Application for a Non-Material Amendment Following a Grant of Planning Permission

Erection of 3.No two storey dwellings with access from Grafton Road

NE/22/00312/FUL

The applicant is seeking to amend the approved drawings for Plot 1 by removing two (pre viously proposed) chimneys down to one chimney.

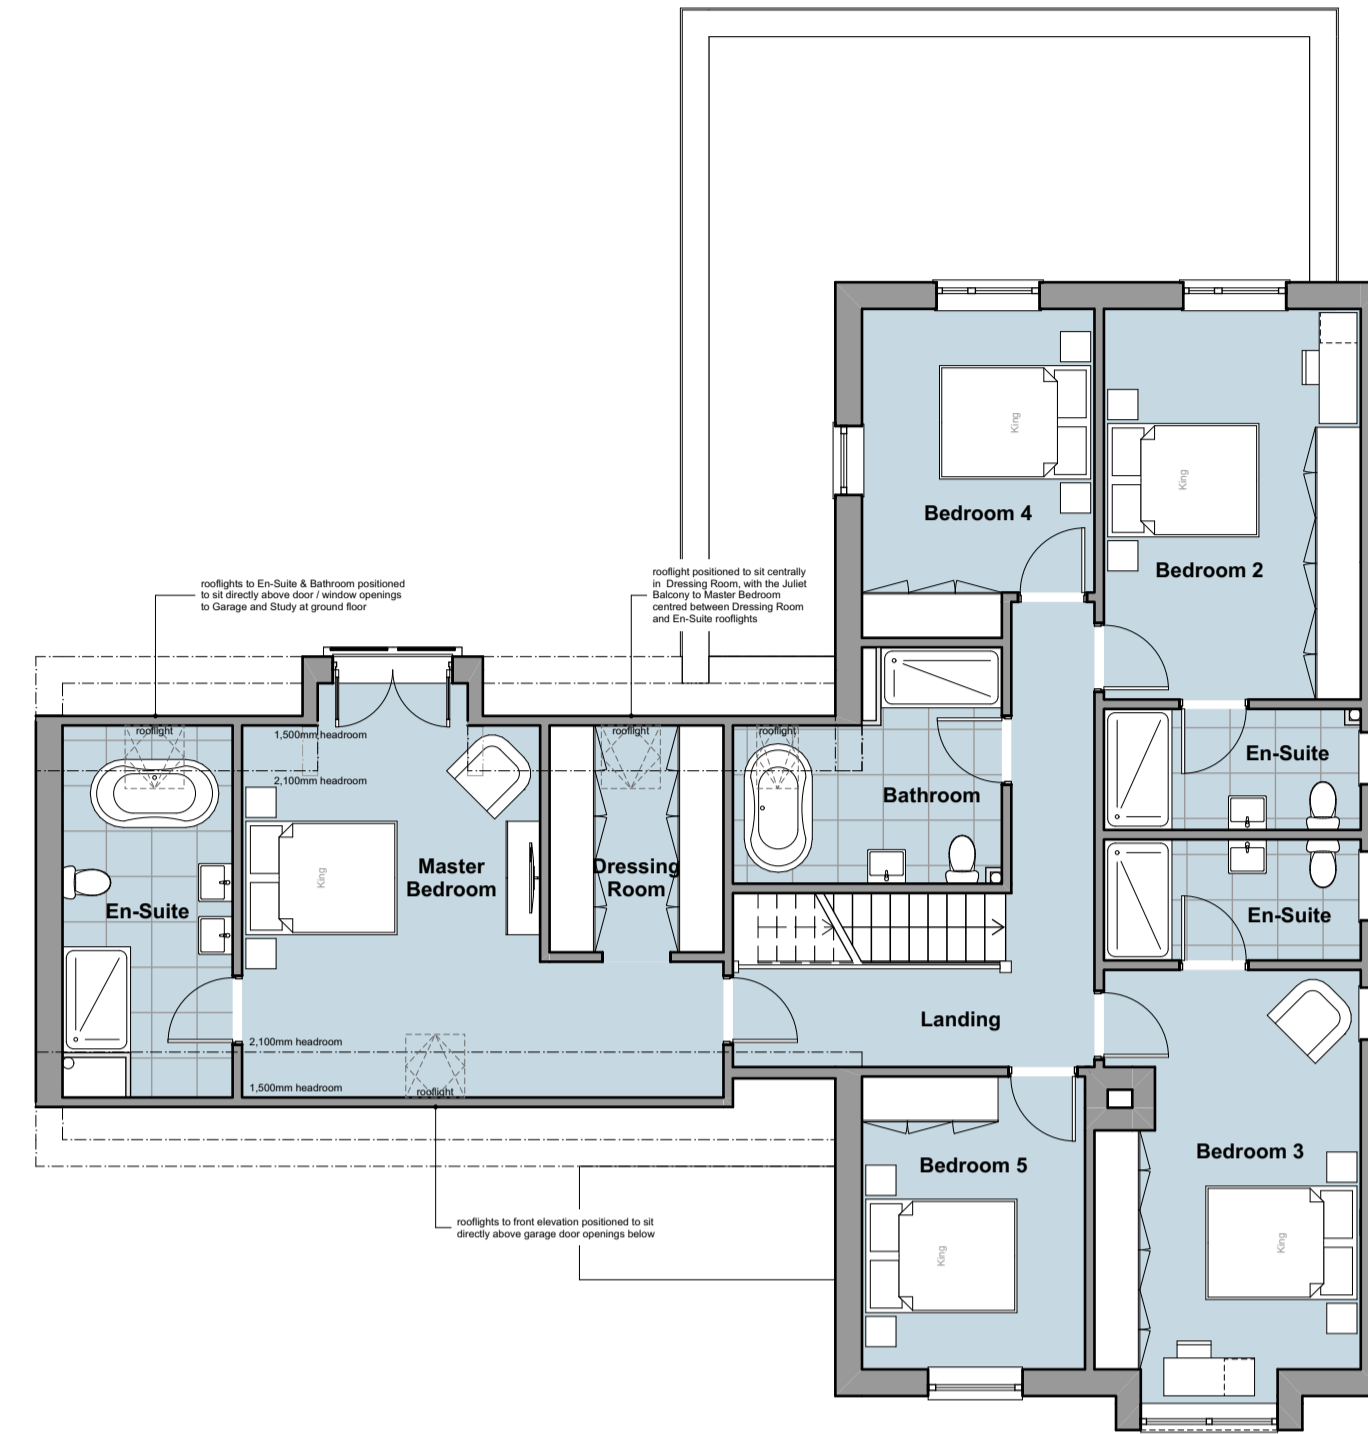
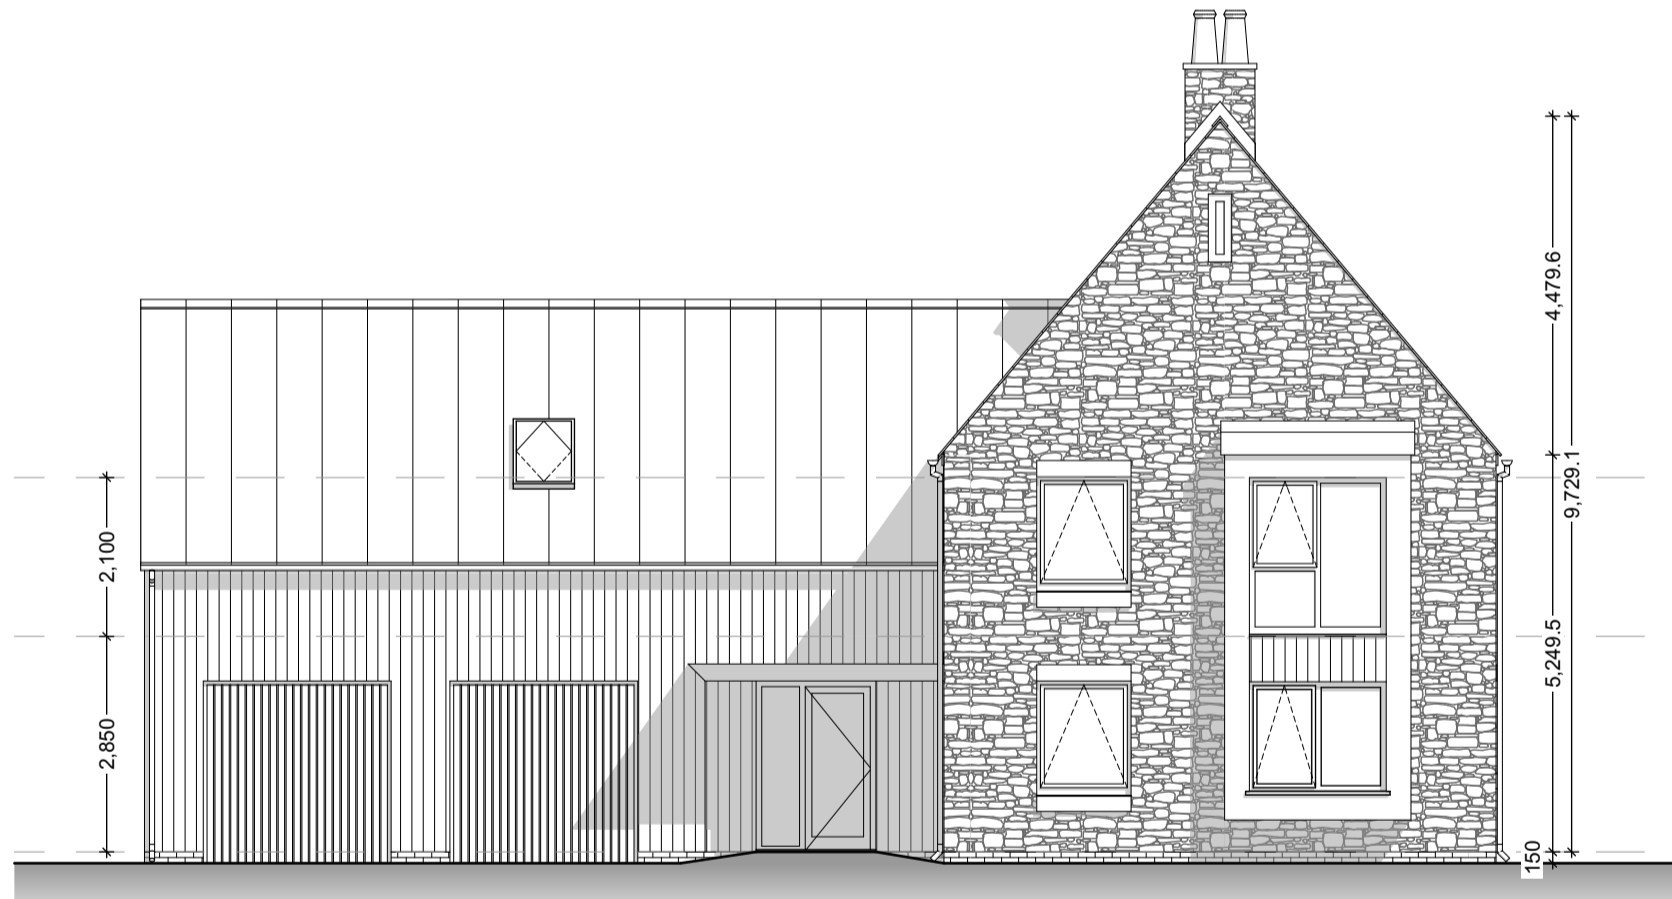
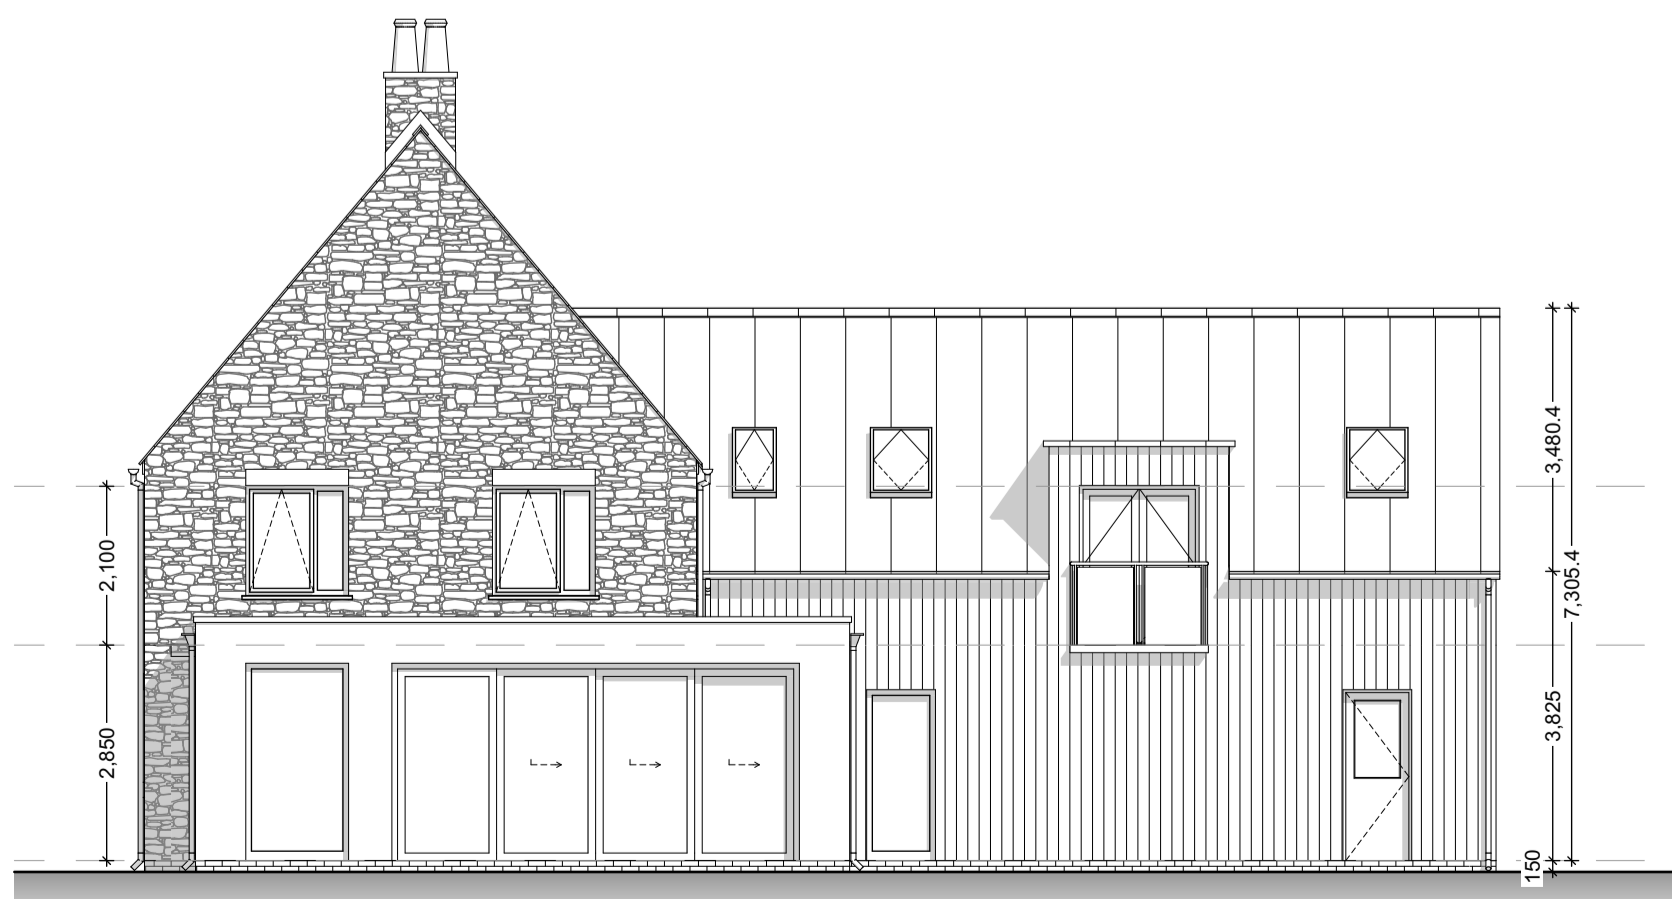
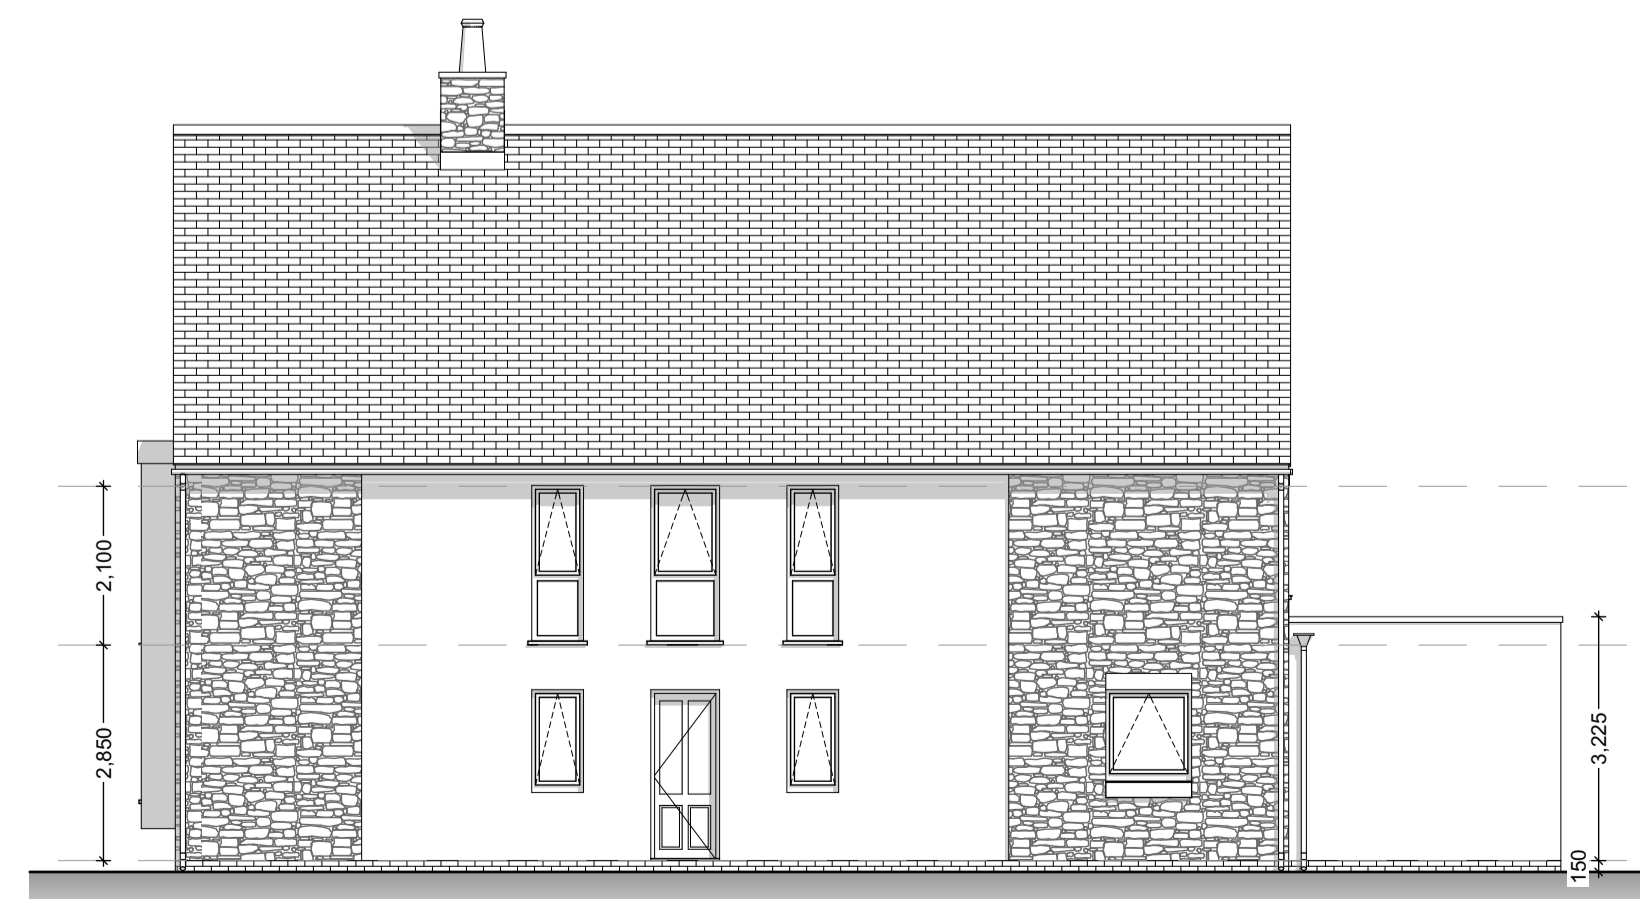
The applicant wishes to keep consistency with the approved plots on site, where plots 2-3 only consist of a single chimney in the 'sitting room'. This change to plot 1 will also create more comfortable spaces within the dwelling by increasing the space in the proposed plant and larder rooms, and also in the bathroom on the first floor.

S245 0200-P05 Plot 1 - Plans & Elevations
